**Re: The M12 (SSI-9364) – Submission on Environmental Impact Statement Amendment**

Council welcomes the opportunity to provide comments on the amended Environmental Impact Statement (EIS) for the proposed M12 Motorway between The Northern Road and the M7 Motorway. A portion of the project is in the Liverpool Local Government Area (LGA).

Figure 2-1 Key features of the amended project

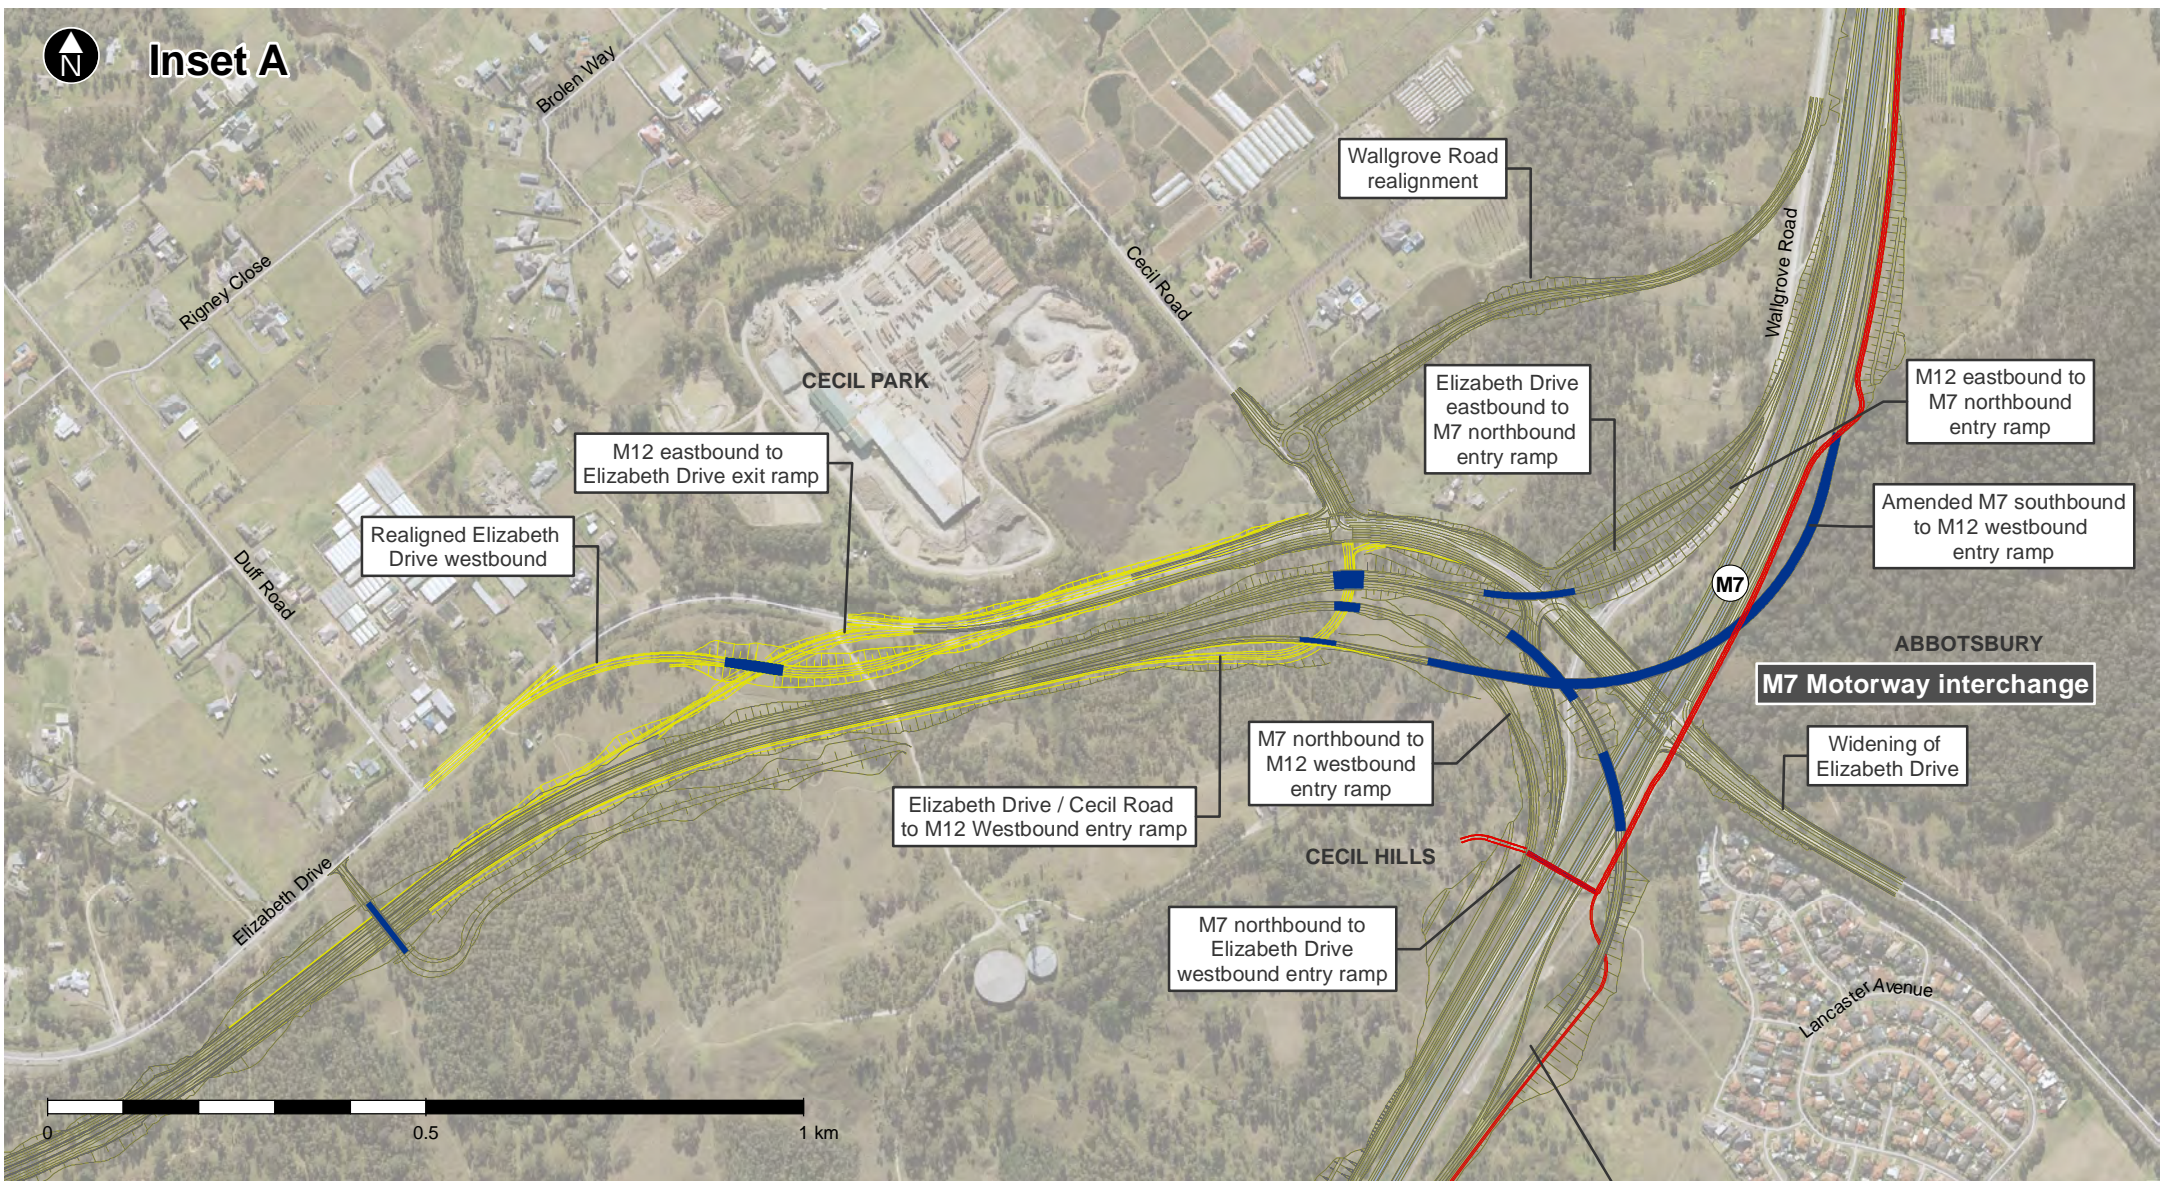
- Council supports the revised design option 2 which would provide the requested direct connection to and from Elizabeth Drive and requests that this option is funded and constructed as part of the project. Such a connection would provide essential local assets (from Fairfield and Liverpool LGAs to the Western Sydney Airport (WSA) via the M12 Motorway).
- Council notes and supports the revised design which will lower the M7 Motorway southbound exit to M12 Motorway westbound, and the M7 Motorway southbound entry from M12 Motorway eastbound, near Cecil Hills.

The revised EIS indicates that the design of the ramp would continue to be refined during detailed design to minimise noise and visual impacts on Cecil Hills residents. It is requested that TfNSW continues to work with Council on the detailed design to ensure that the revised design features would minimise noise and visual impacts (on Cecil Hill residents).
